**Hastings Secondary College Port Macquarie Campus Upgrade (SSD-11920082)
Response to Submissions**

Attachment 1

**Staging Plans**  
Staging Plan Port Macquarie Campus - Stage 1

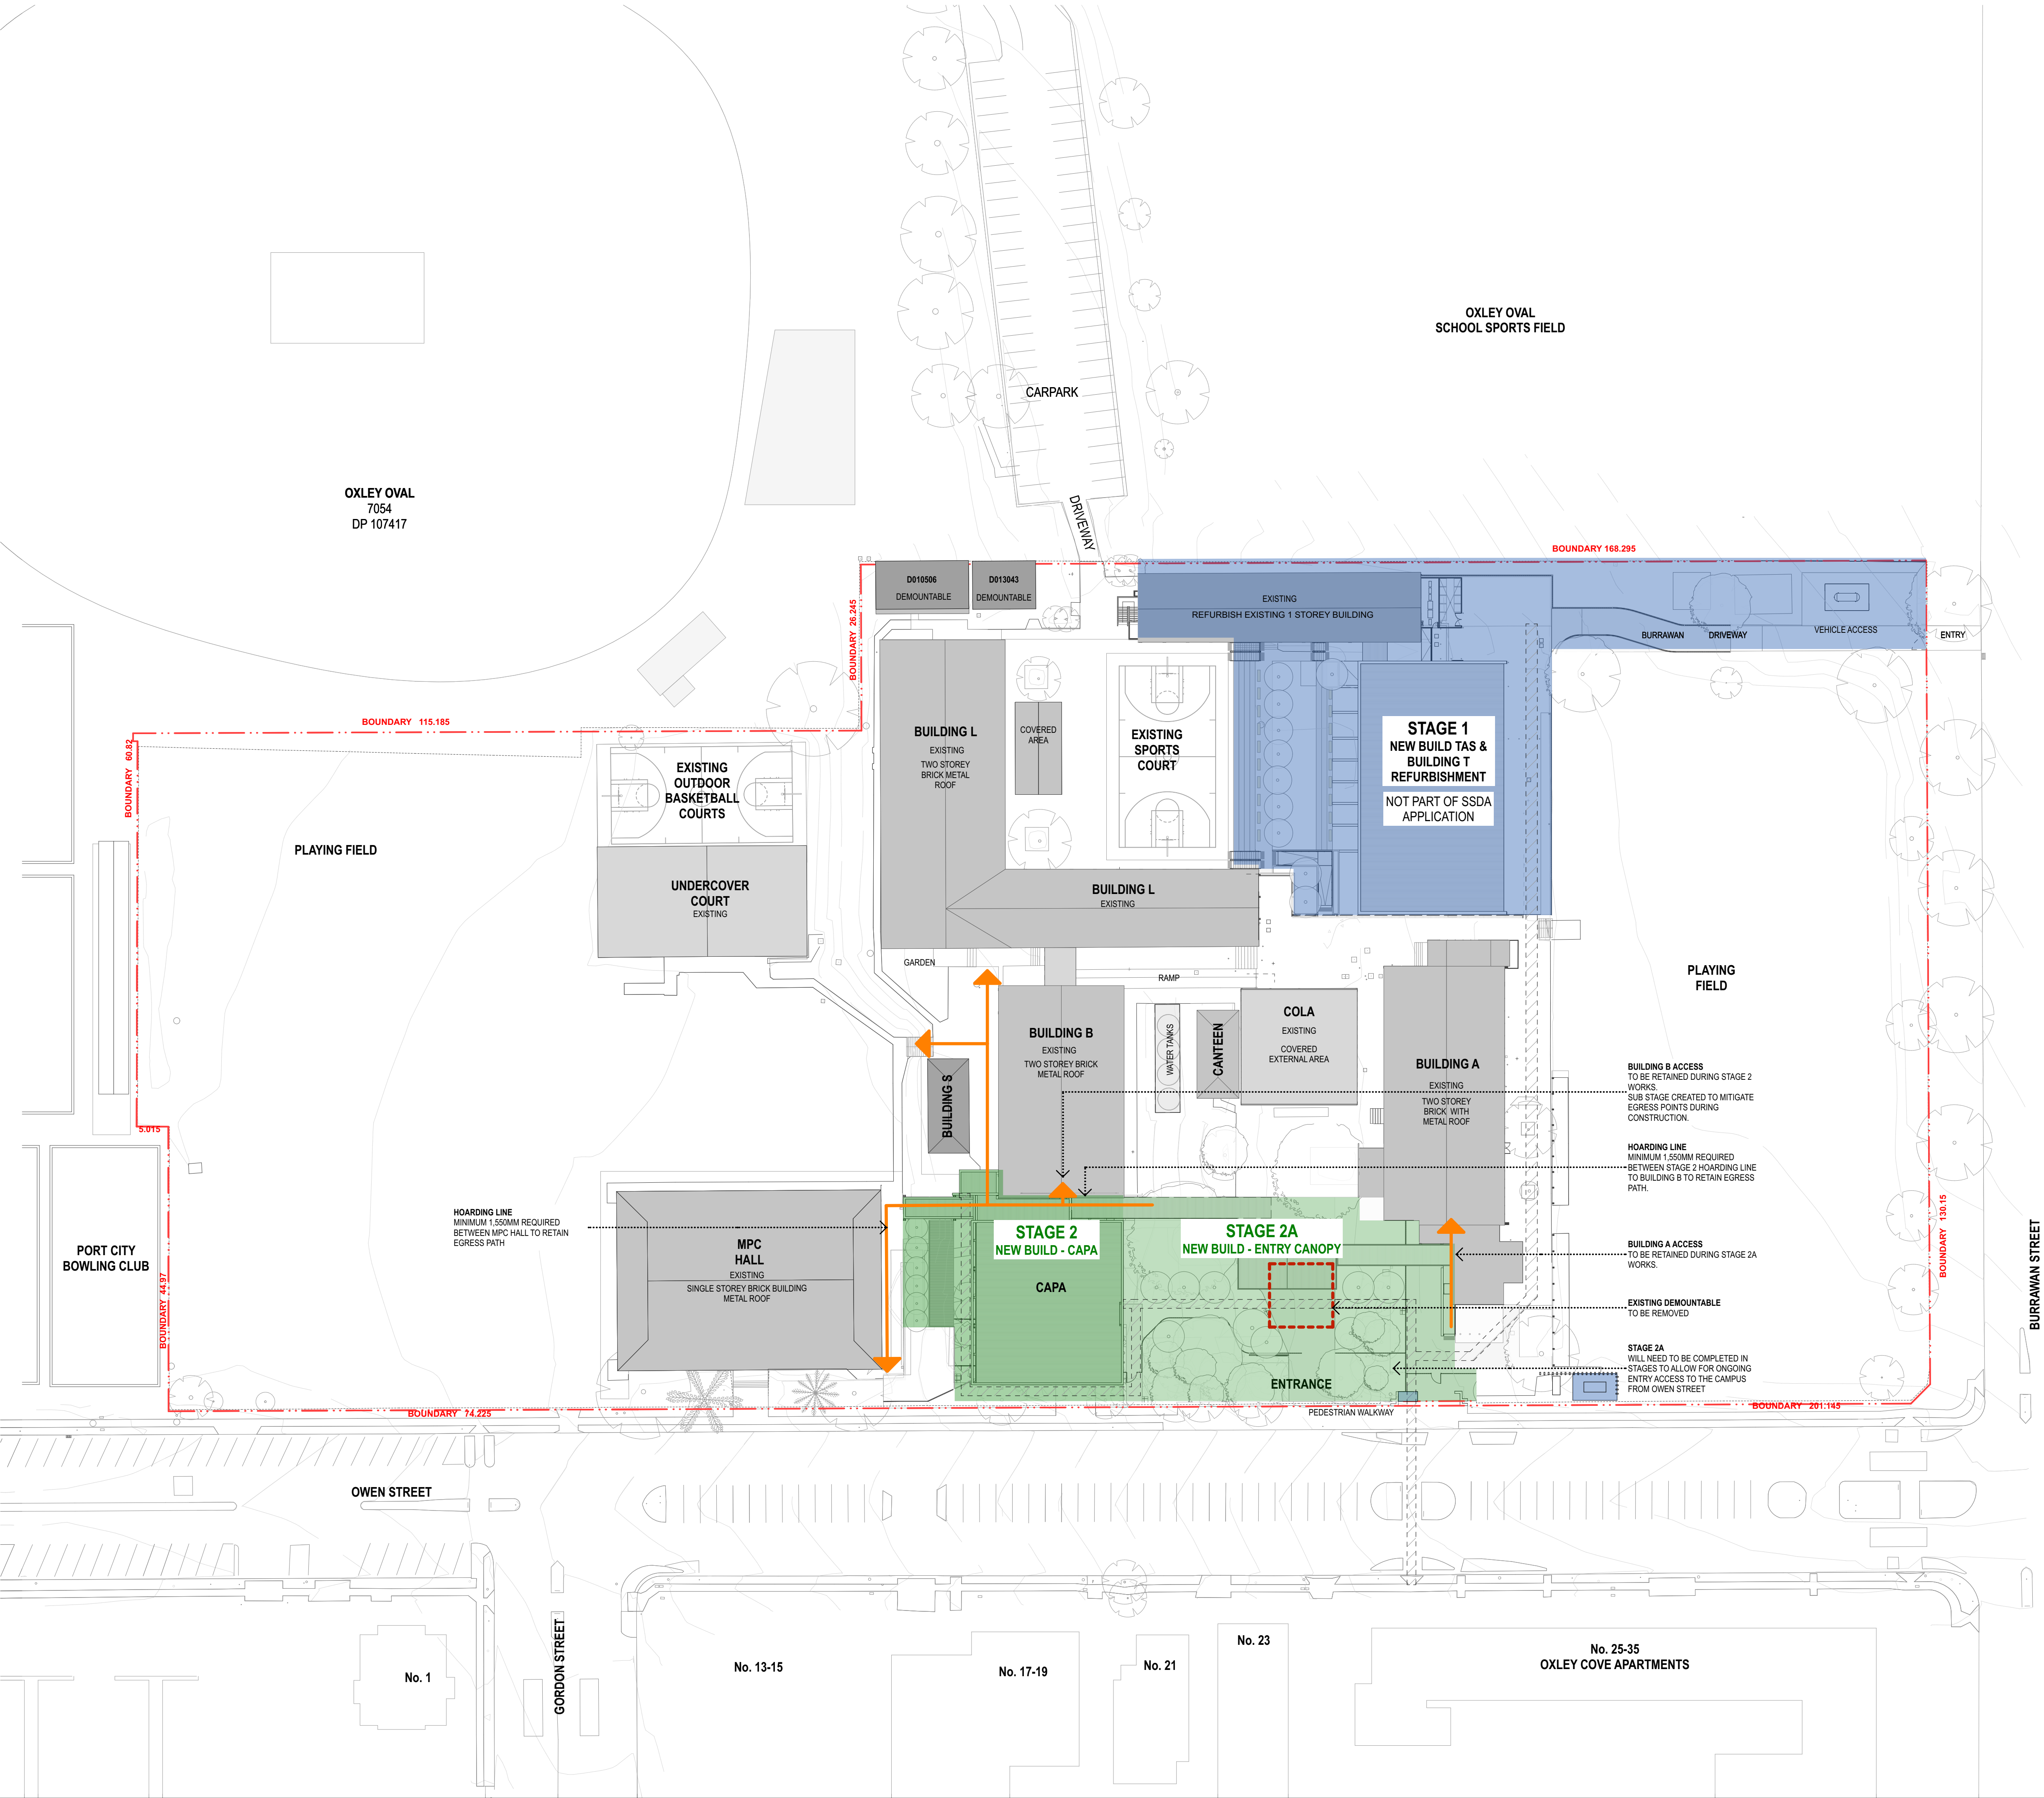
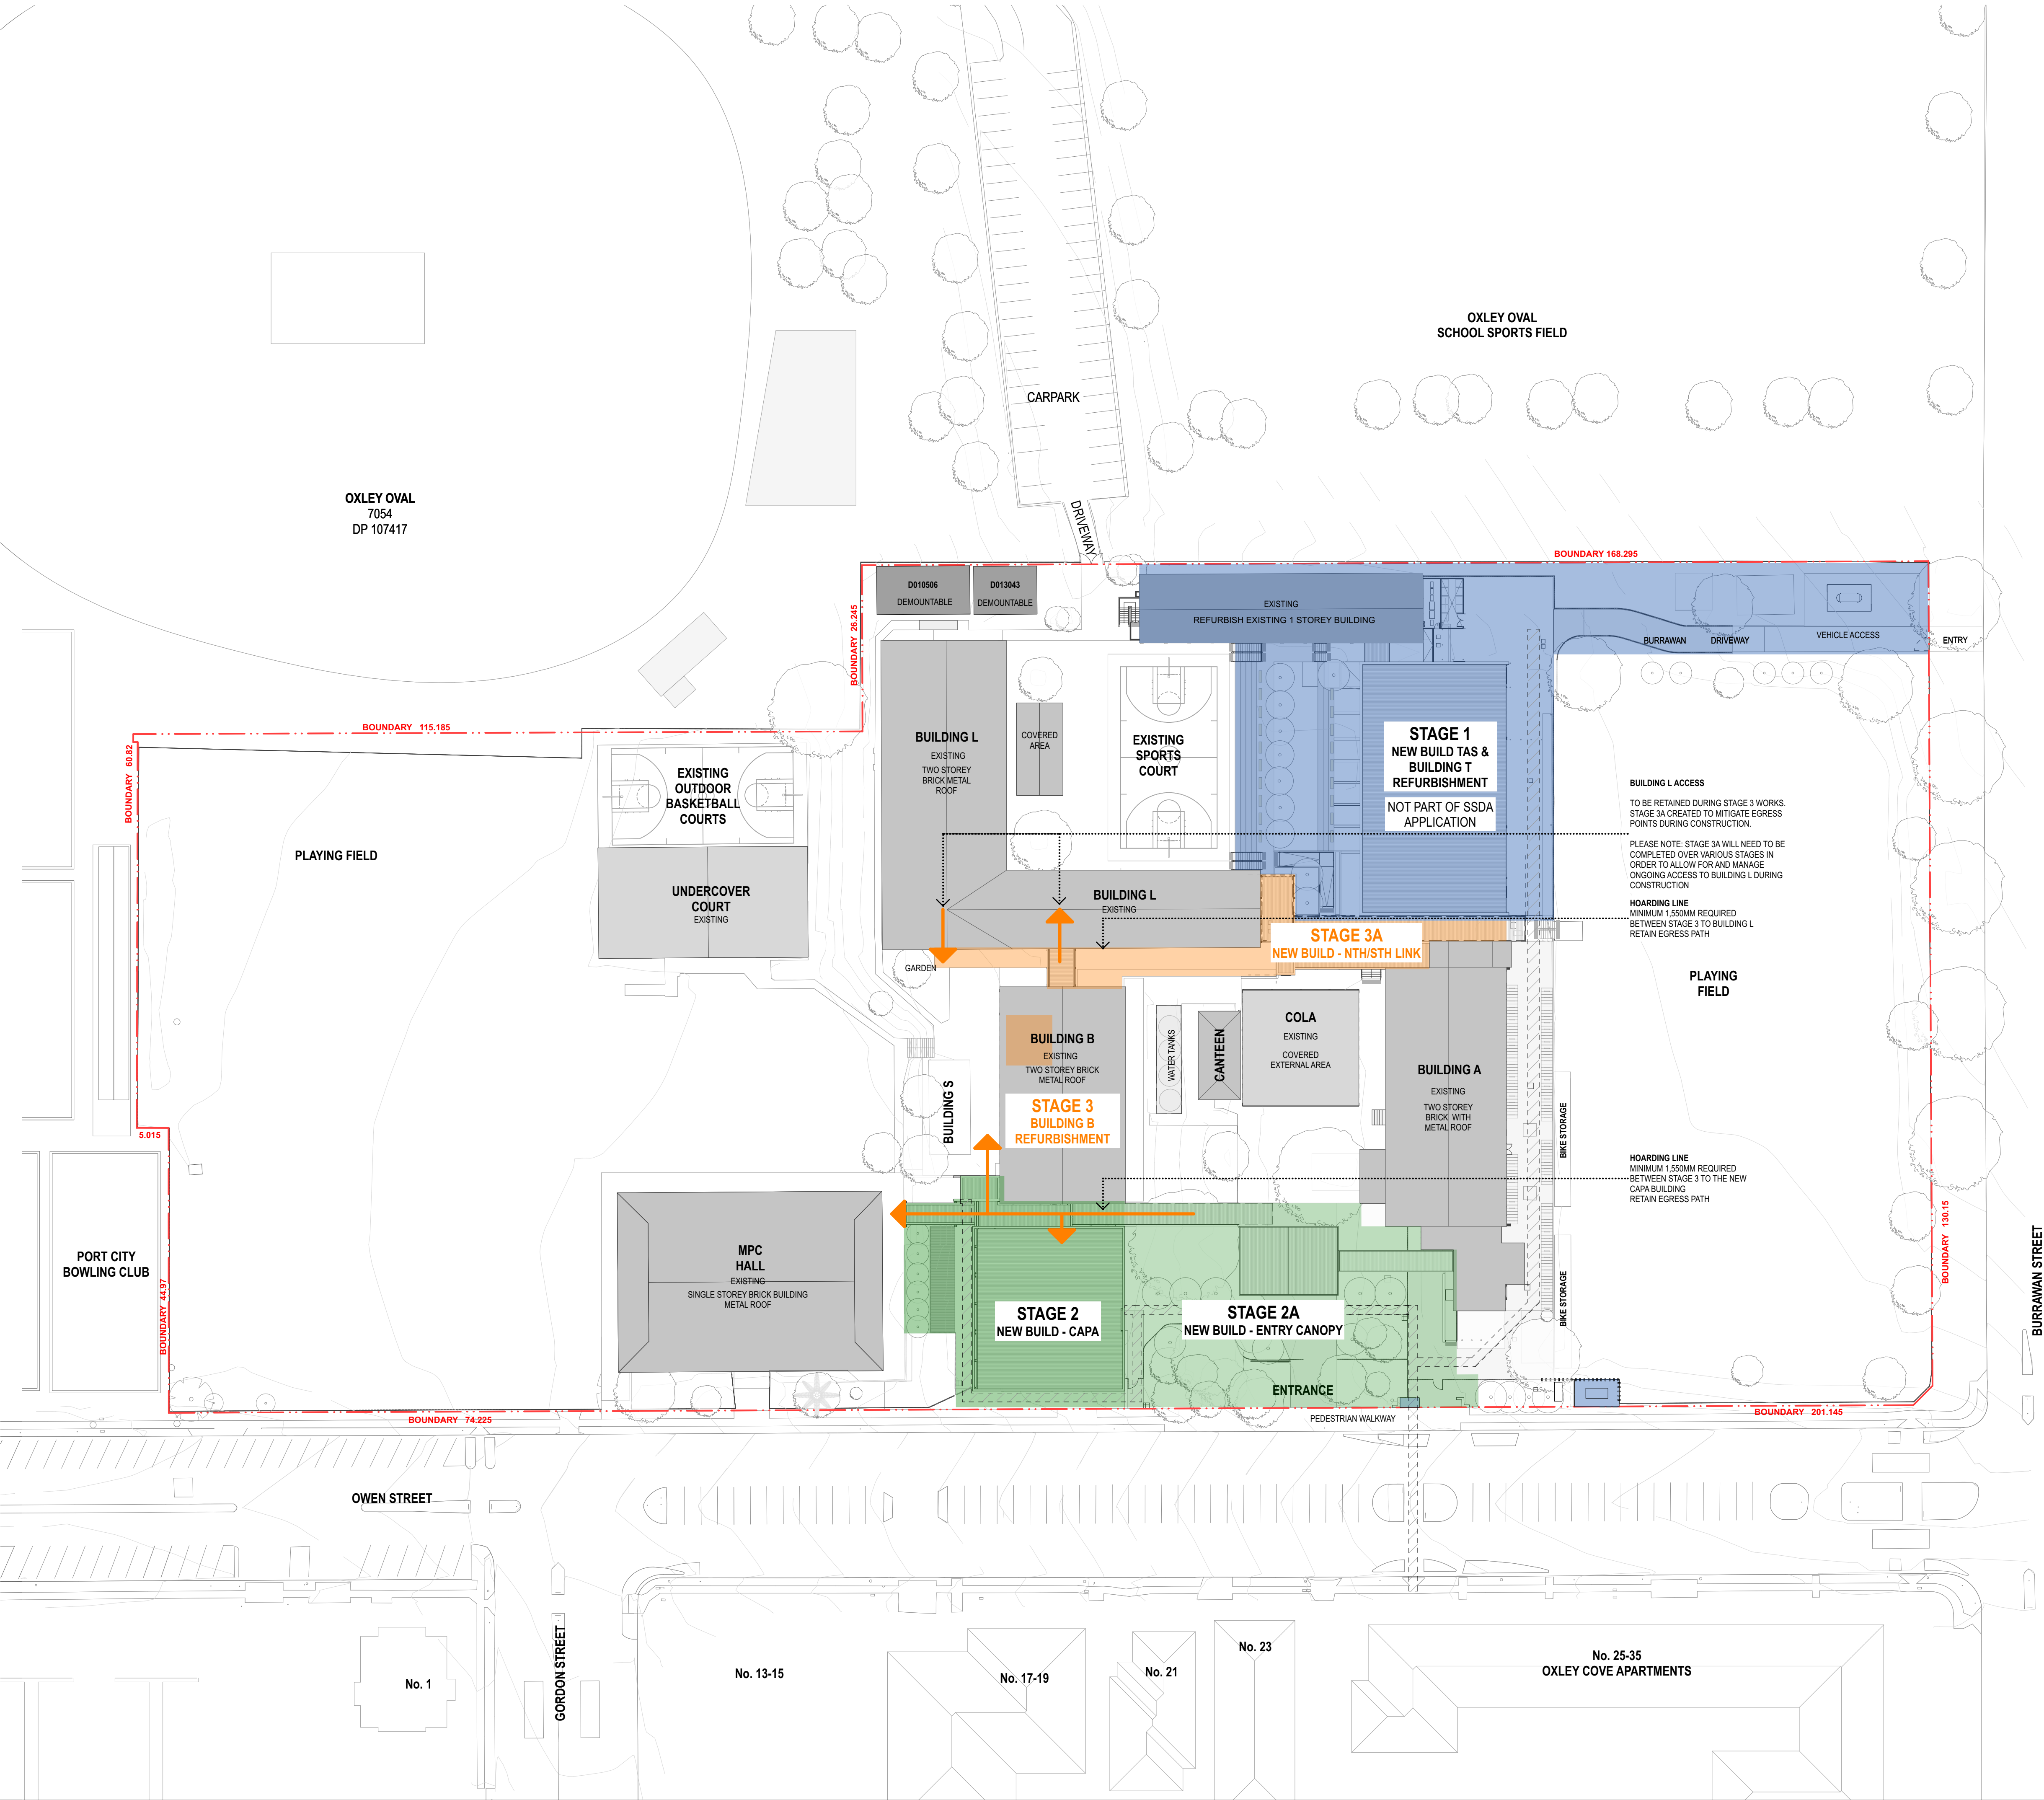
- Further consultation should be undertaken and additional information provided in relation to potential conflicts between continued operation of the school alongside construction activities, including construction traffic. Areas where construction cannot occur (No Go Zones) should be identified along with designated and potentially available construction zone areas. This should be provided to better inform the planning of construction activities and maintaining a quality and safe learning environment for students, teachers and other stakeholders and minimise risks of conflict with construction activities. This information should be shared with consultants engaged in construction management impacts, particularly traffic and noise/vibration, their reports updated and further information provided in the RtS.
